**RE: SECTION 4.55(2) APPLICATION TO MODIFY (MODIFICATION No. 2)  
DEVELOPMENT CONSENT SSD-11920082  
HASTINGS SECONDARY COLLEGE – PORT MACQUARIE CAMPUS  
16 OWEN STREET, PORT MACQUARIE**

**RE: Response to Request for Additional Information**

title  
**1:100 Elevations**  
**Elevations - PCYC East West**

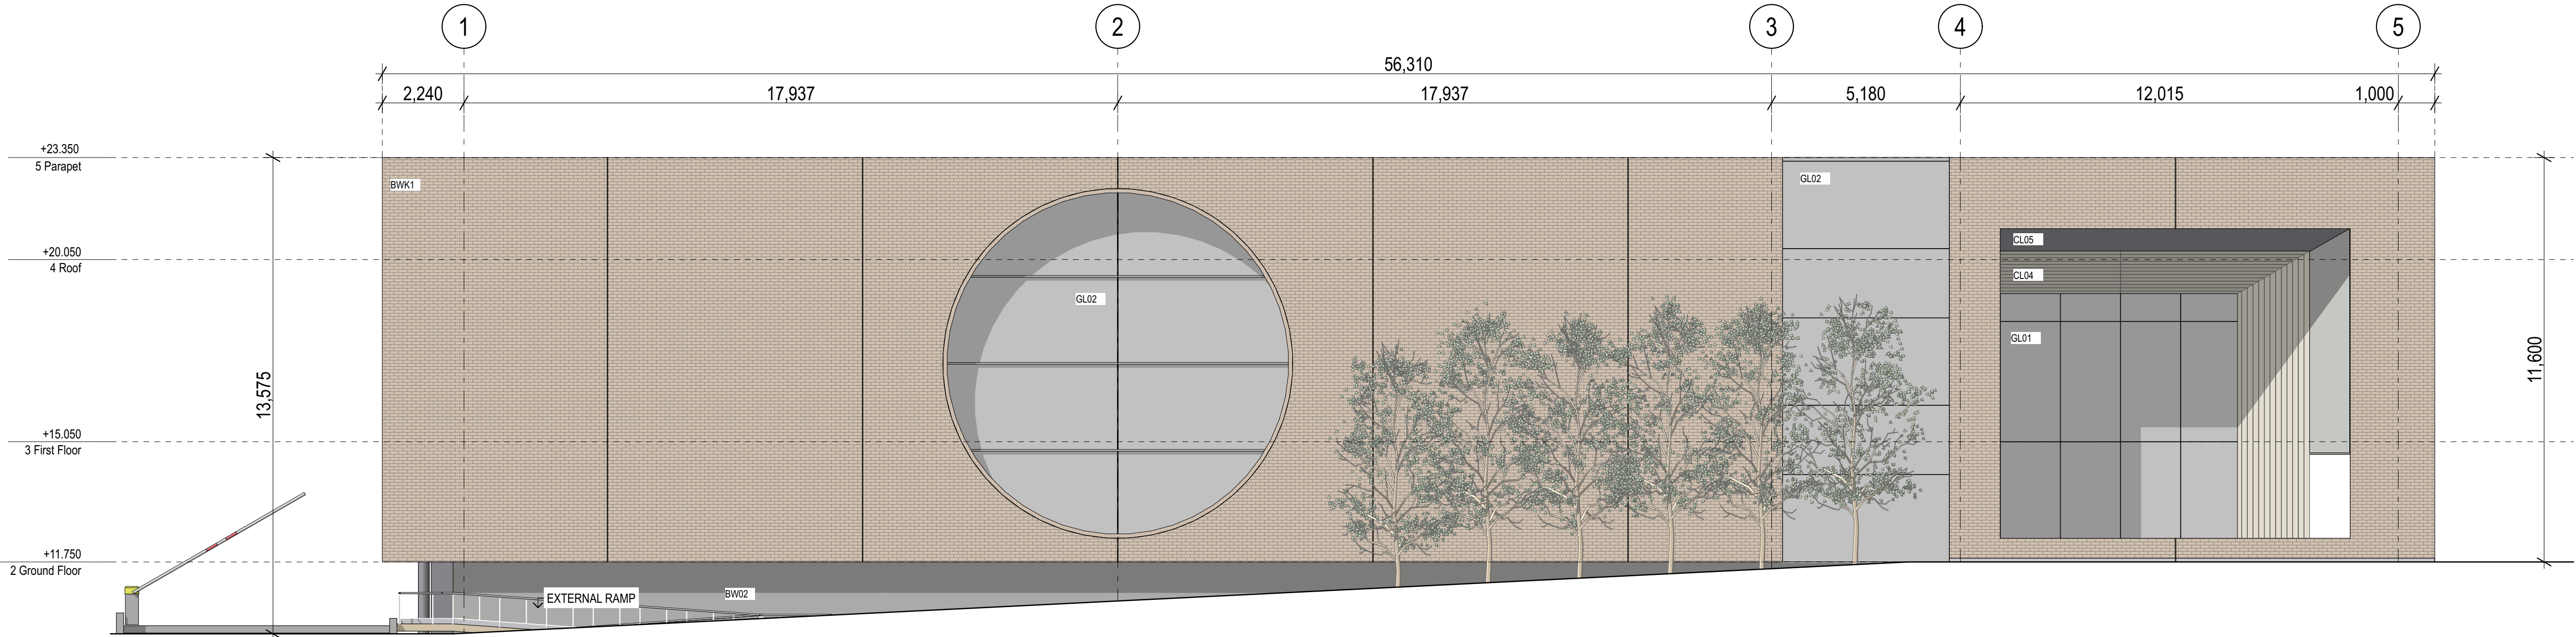
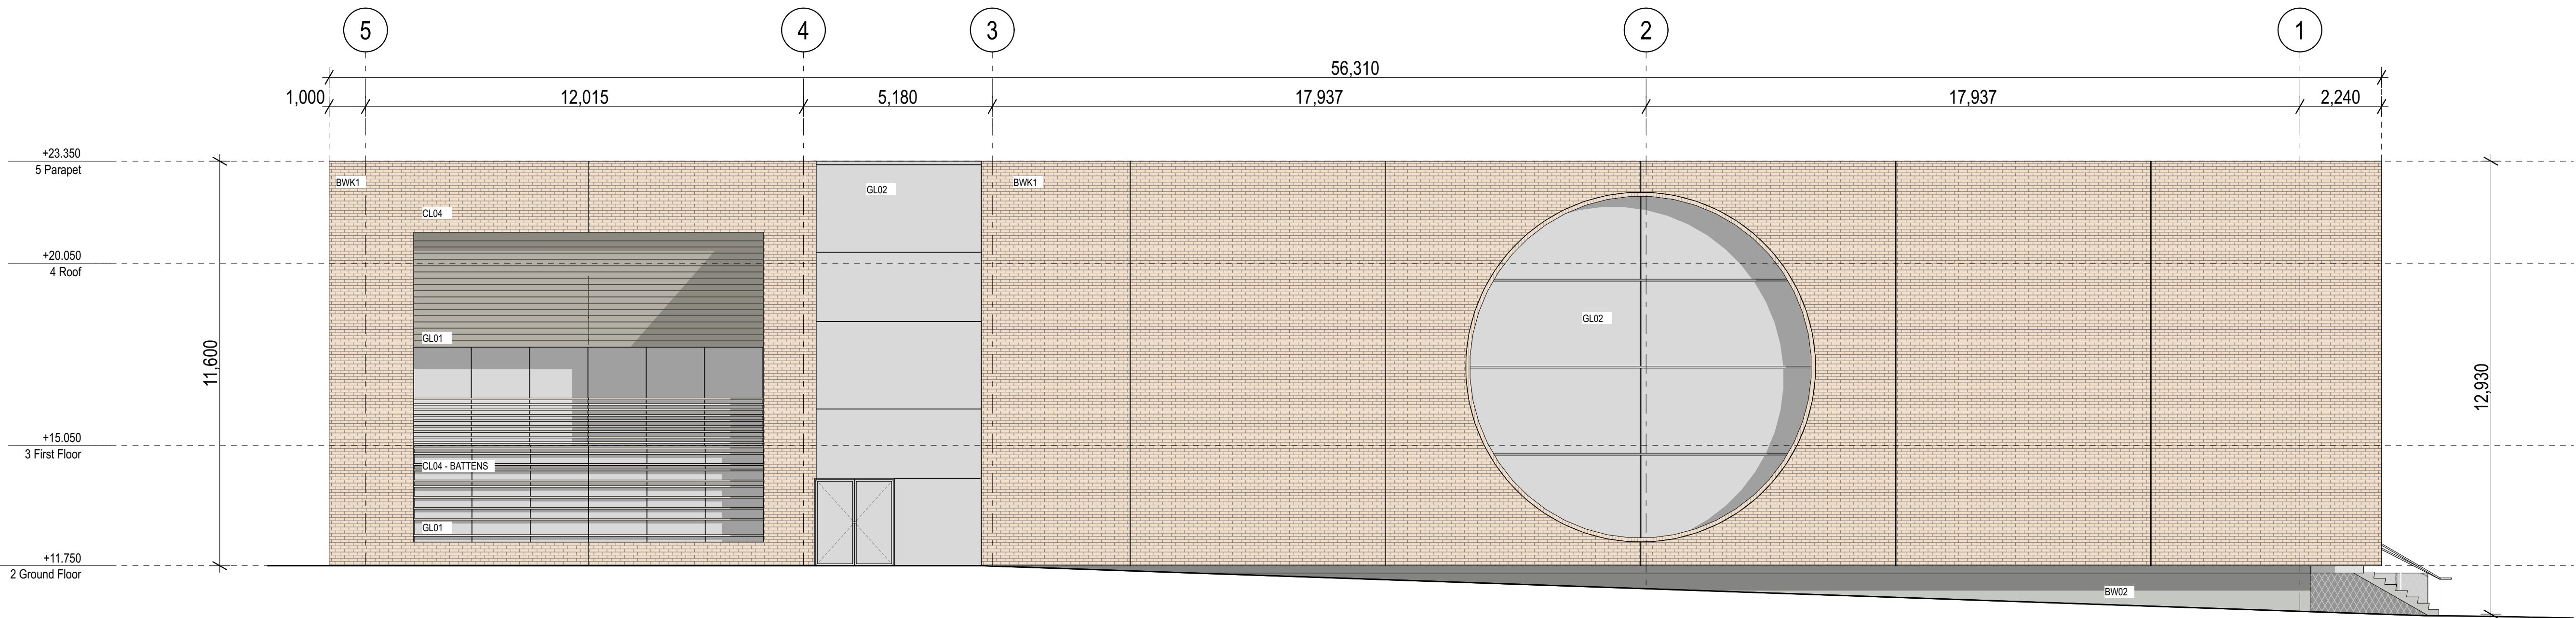
1. *The proposed amended materials of the PCYC façades do not reflect the key design principles identified in the Architectural Design Statement provided as part of the EIS.*
2. *Cladding would not be complimentary to the scale and texture of the existing and heritage connection of the site. The proposed materials do align with the existing heritage framework of the 1960s campus consisting of an established language of two storey, face brick forms with low pitched metal roofs. The Statement of Heritage Impact provided as part of the EIS suggests that the proposed use of bricks (similarly toned to the existing bricks on site), off form concrete and steel roofing would respond to the predominant existing materials used at the site.*
3. *The fibre cement panelling would exacerbate the visual perception of bulkiness as opposed to the approved brickwork.*

Whilst amended plans have not been provided, a response has been prepared by both School Infrastructure NSW and the project architect outlining how the project reflects the key design principles and the reasoning/ justification behind the material changes on the facade of the PCYC building.
